PROPOSED ROADWAY PLANS FOR JUDGE ORR ROAD RV PARK & STORAGE EL PASO COUNTY, COLORADO

APRIL 2022

PDC PROJECT # CDR-22-002

SHEET TITLE: ROADWAY OVERALL NOTES & DETAILS

RANGE FLOWER WAY ROADWAY PLAN (PRIVATE)
URBAN NON-RESIDENTIAL COLLECTOR
SCALE = 1" = 60'

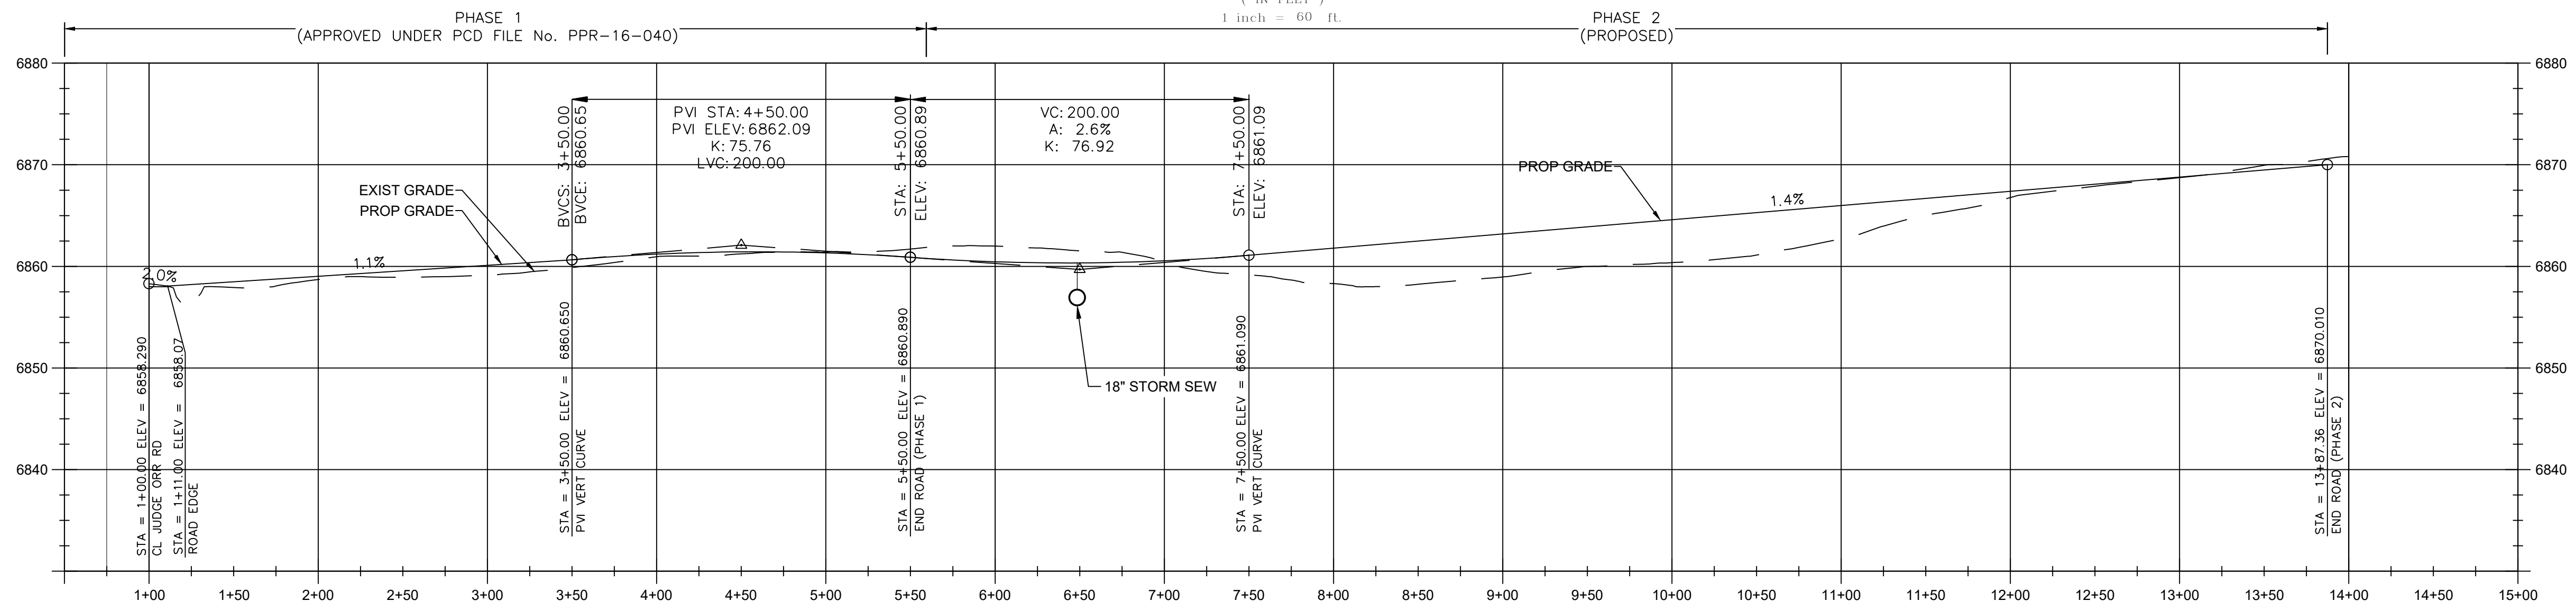
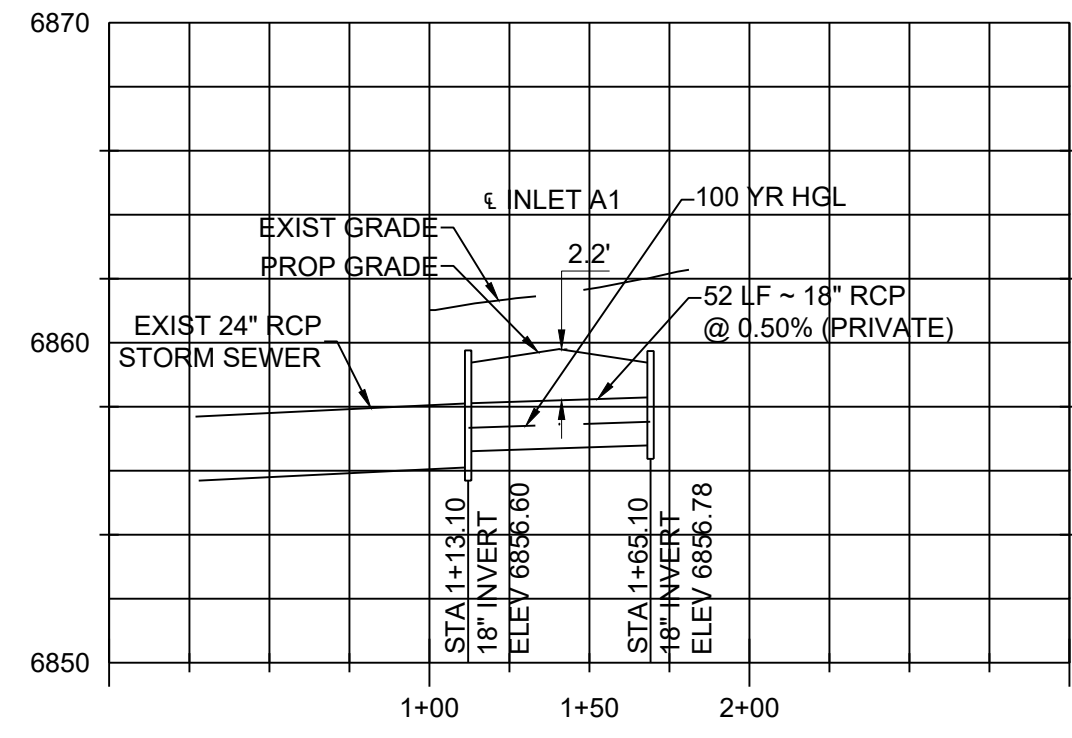
Add note on sidewalk
 Future Sidewalk on West side of Range Flower Way (Private)

Future Sidewalk on West side of Range Flower Way (Private)

URBAN NONRESIDENTIAL COLLECTOR ROADWAY DETAIL
N.T.S.

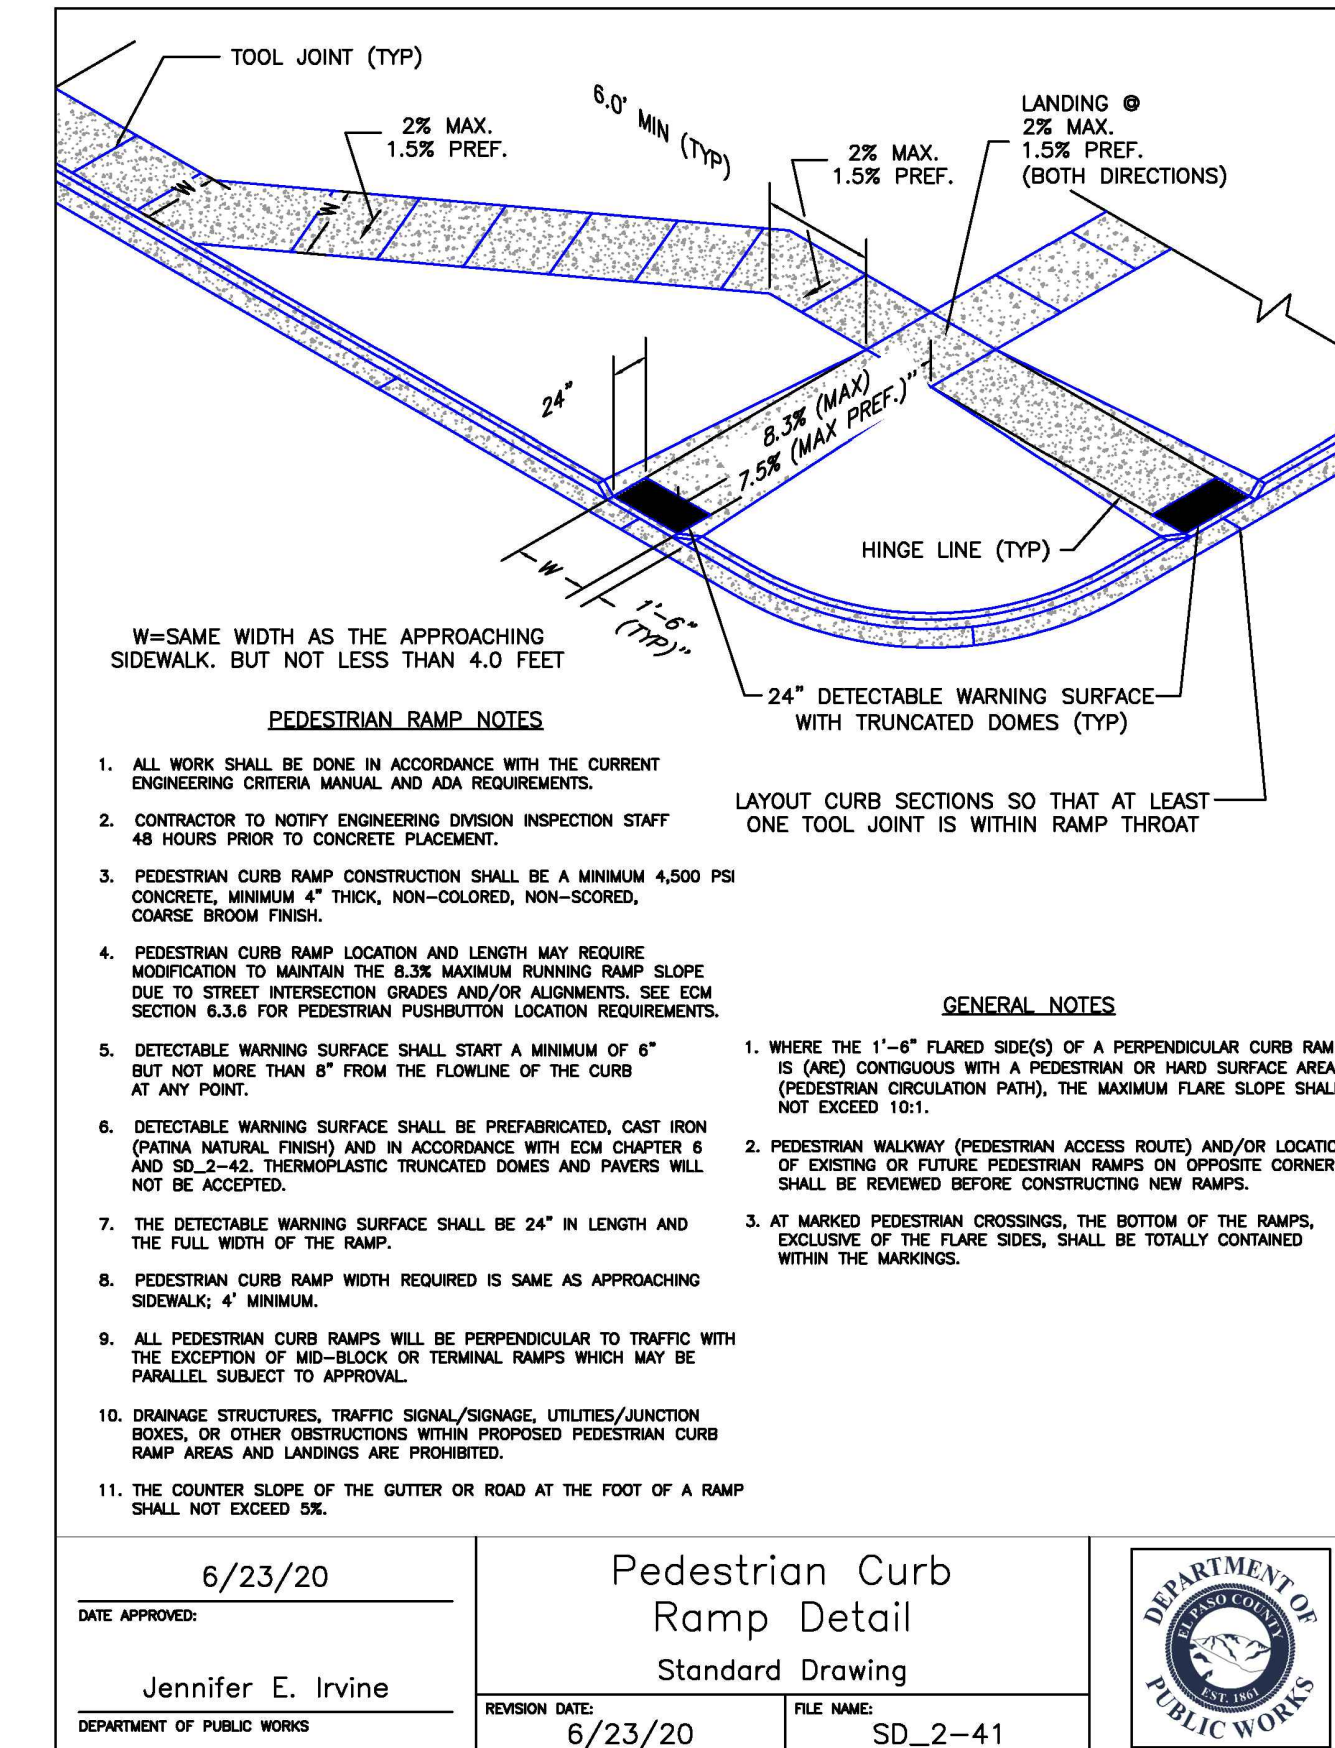
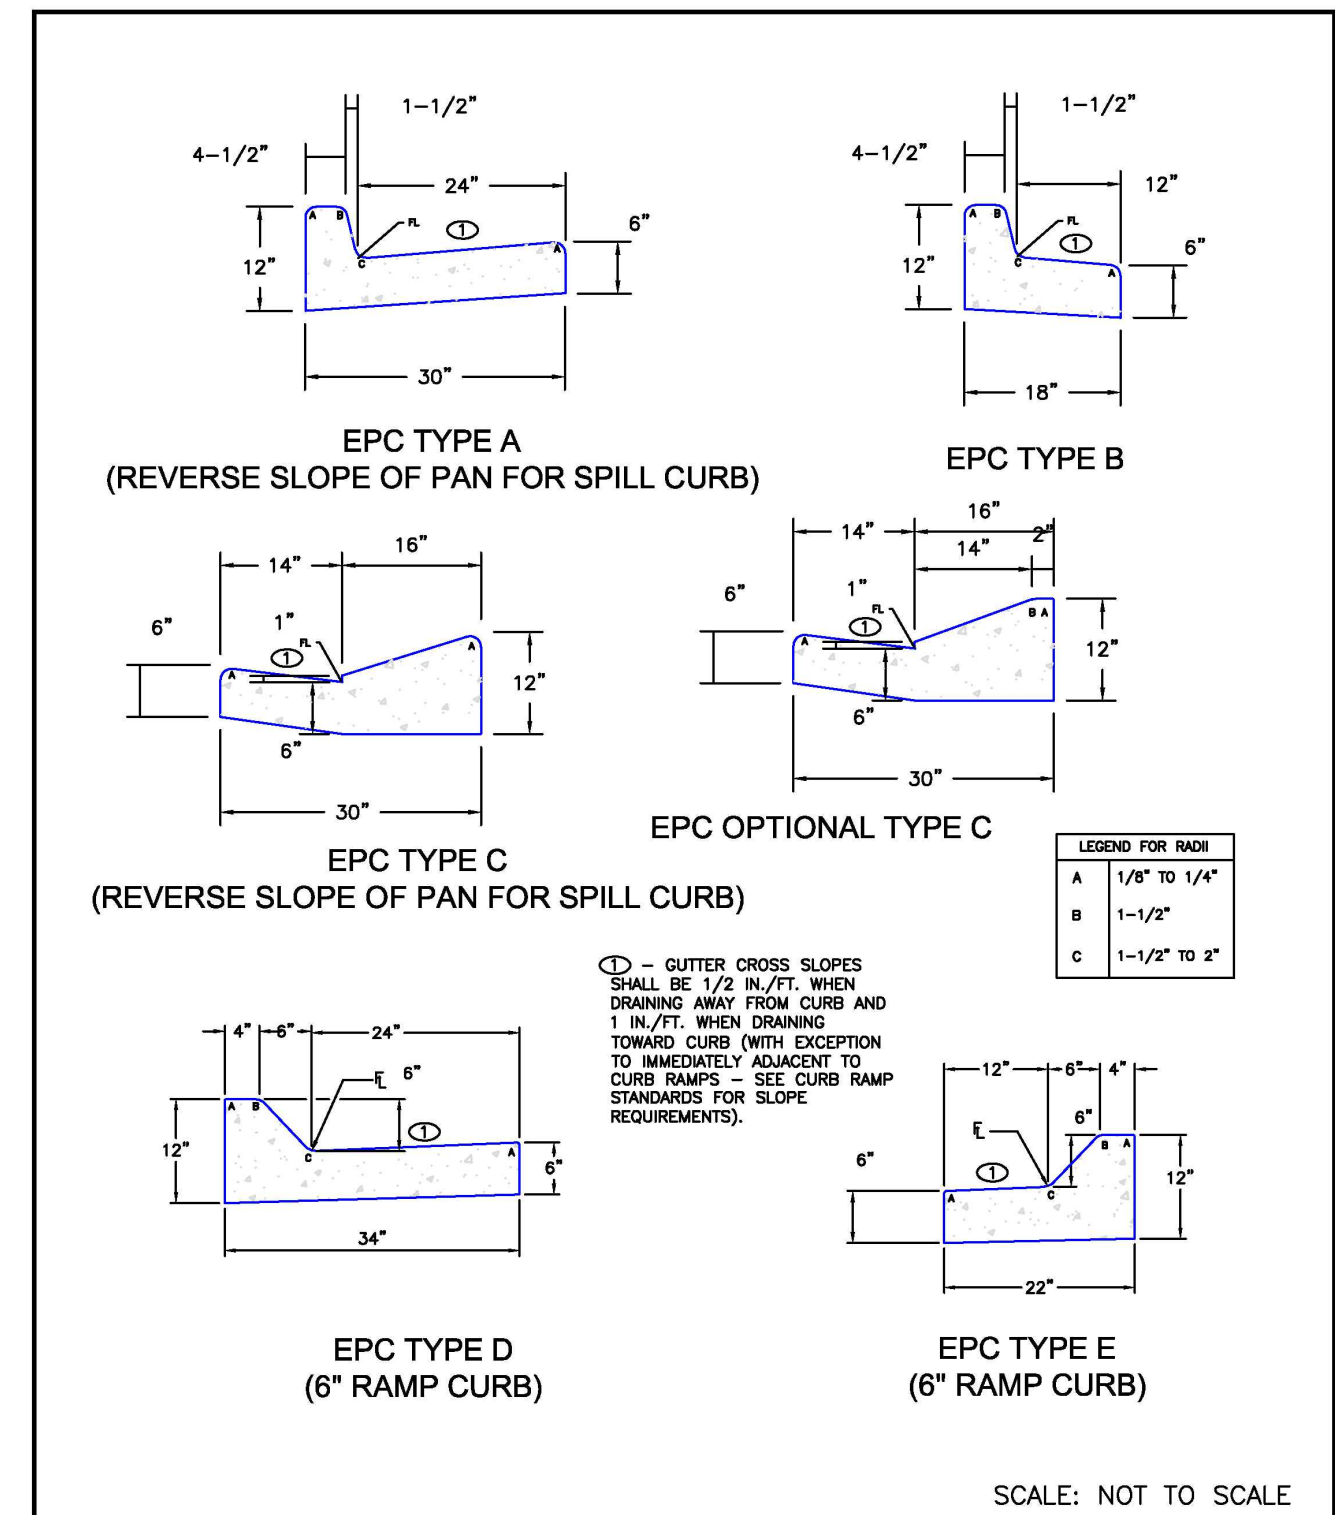
Please replace urban residential collector with SD 2-3 Urban Non-Residential Urban Collector

Please add note or add SD-2-42 drawing
